**Application by Mallard Pass Solar Farm Limited
for an Order Granting Development Consent
for the Mallard Pass Solar Project
– project ref. EN010127**

Submission by Sue Holloway – unique ID ref. 20036112

Final Summary Statement

16th November 2023

DRAWING TITLE
Figure 6.11: Green Infrastructure Strategy Plan

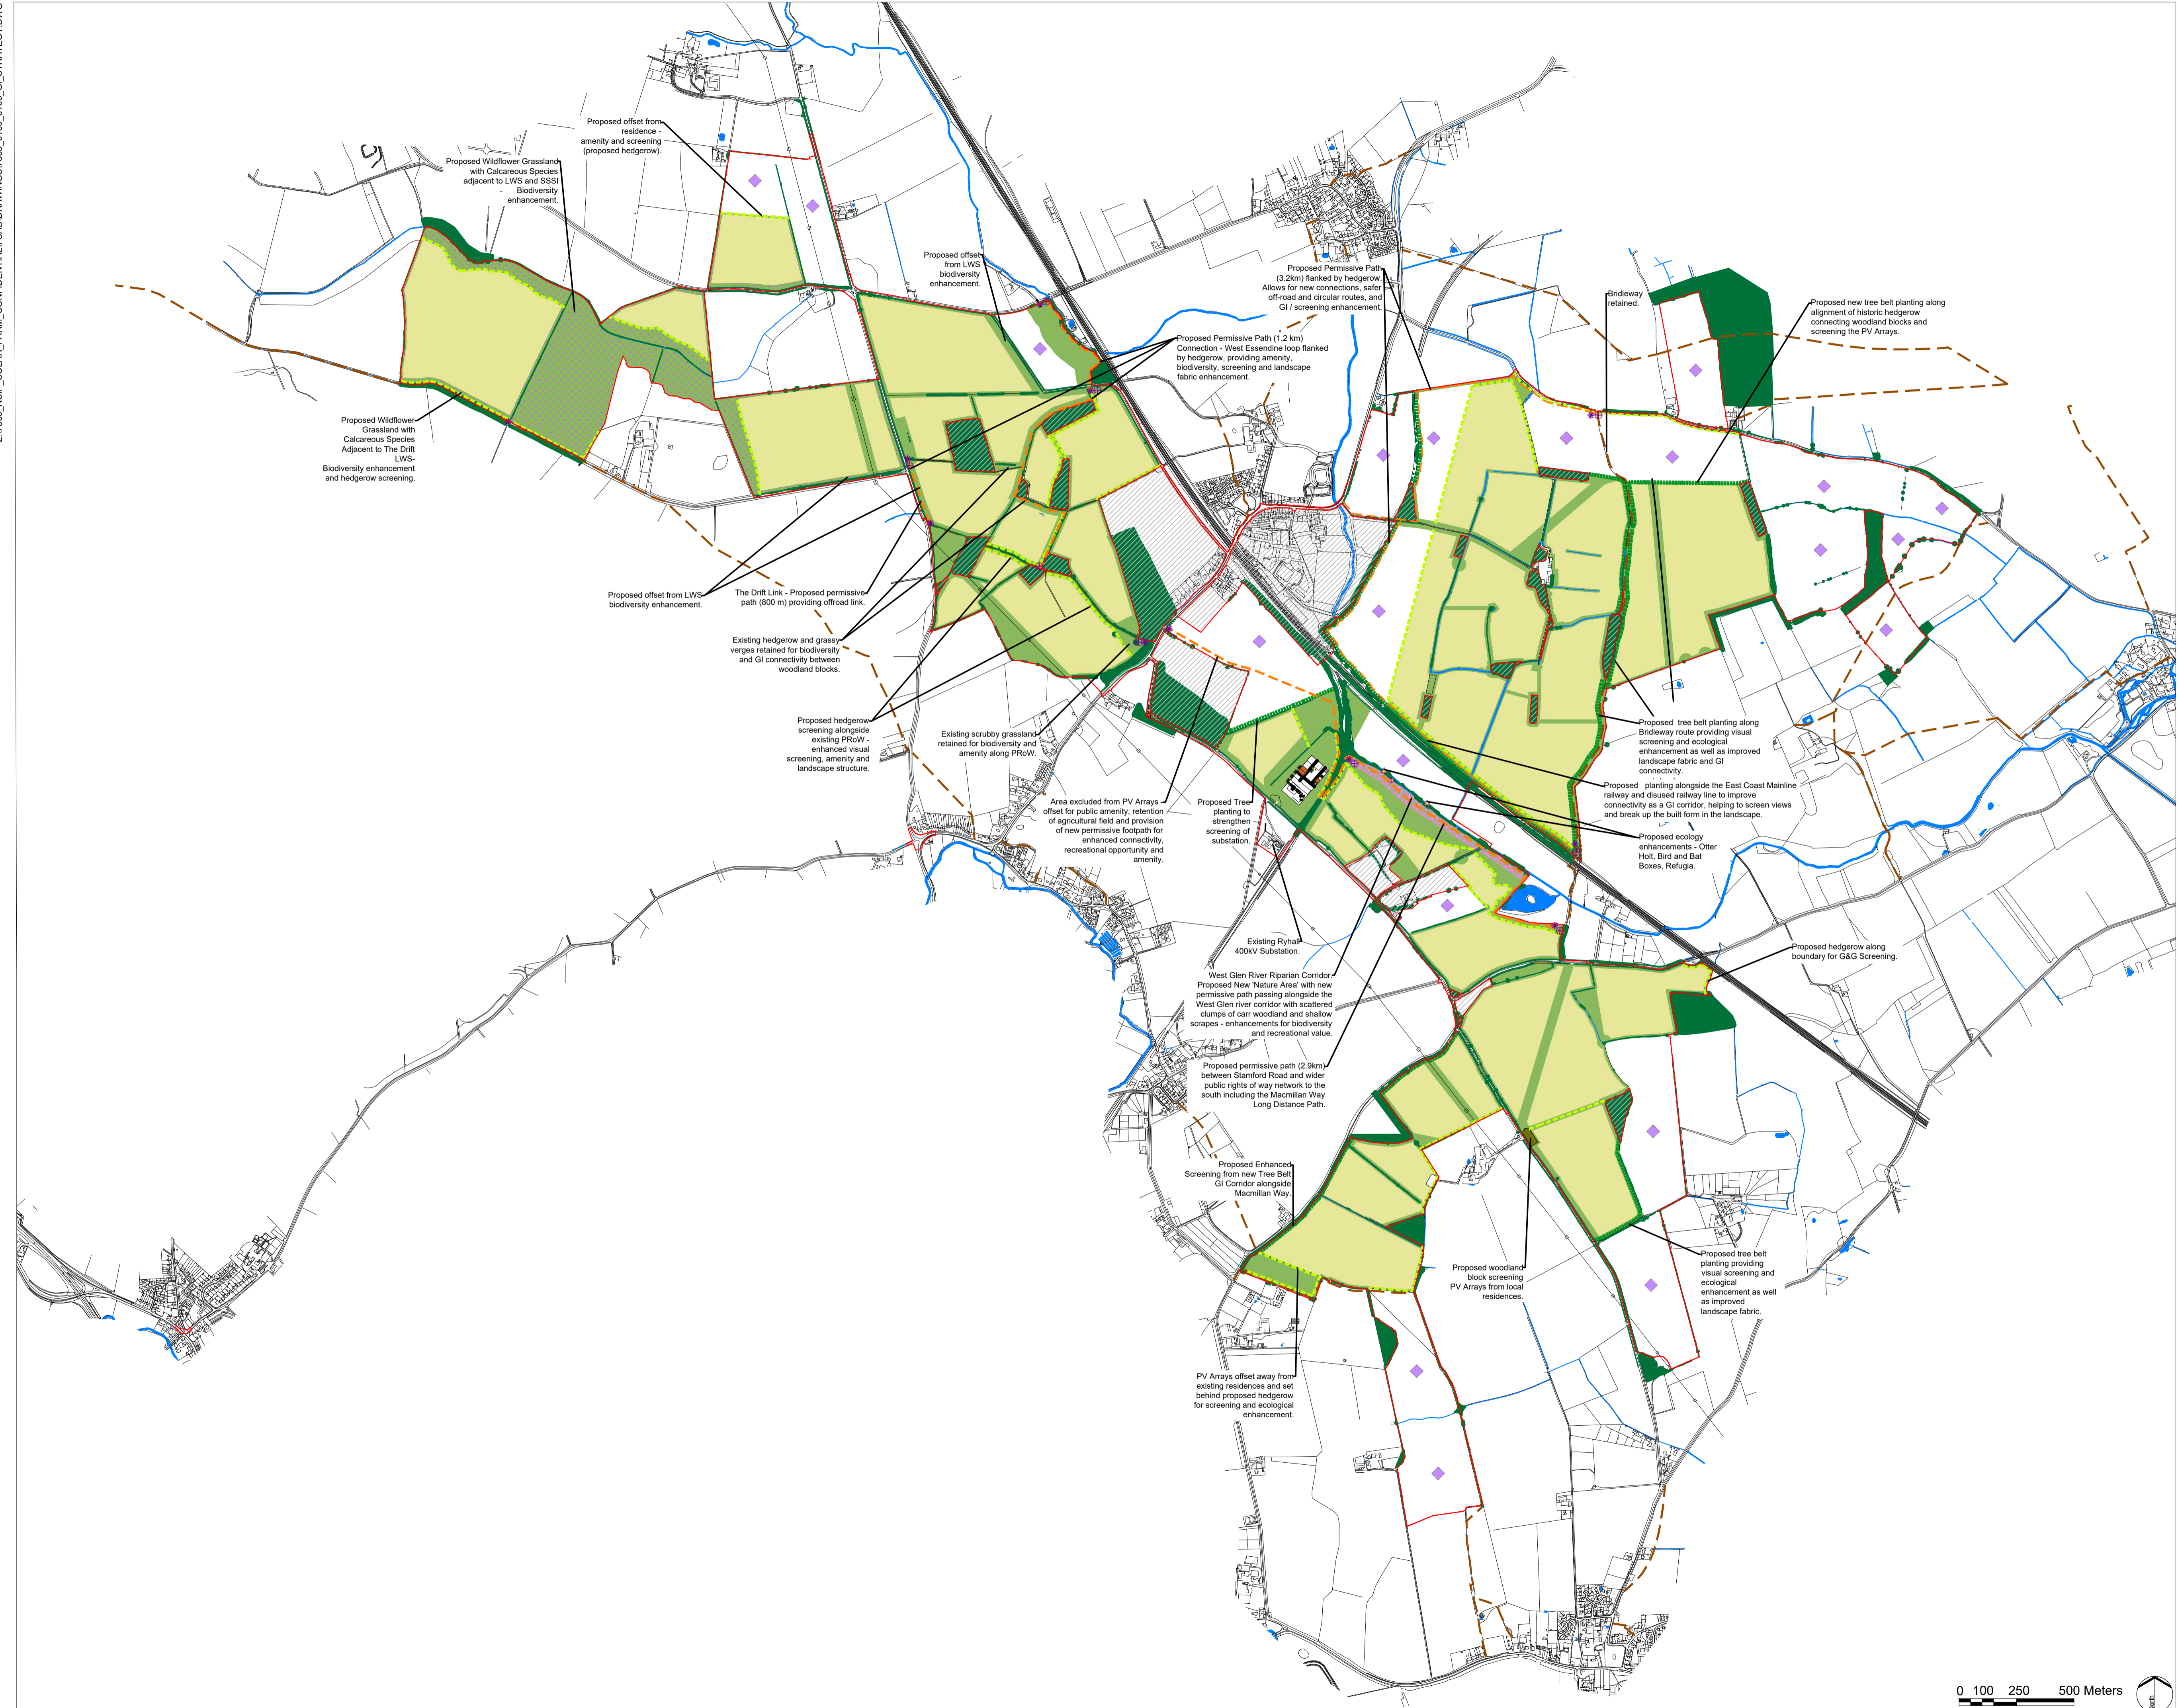
3. Field 36 screening along the set back. The RVIA and Green Infrastructure Strategy plan mention 2 different approaches, one hedging, the other a tree belt. I have argued against the tree belt because:

- a. it is in a place where a historic hedgerow used to be
 - b. it would look out of place in such an open vista compared to a hedgerow.
 - c. The screening would be less effective than a hedge in winter and would take much longer than 15 years to establish.
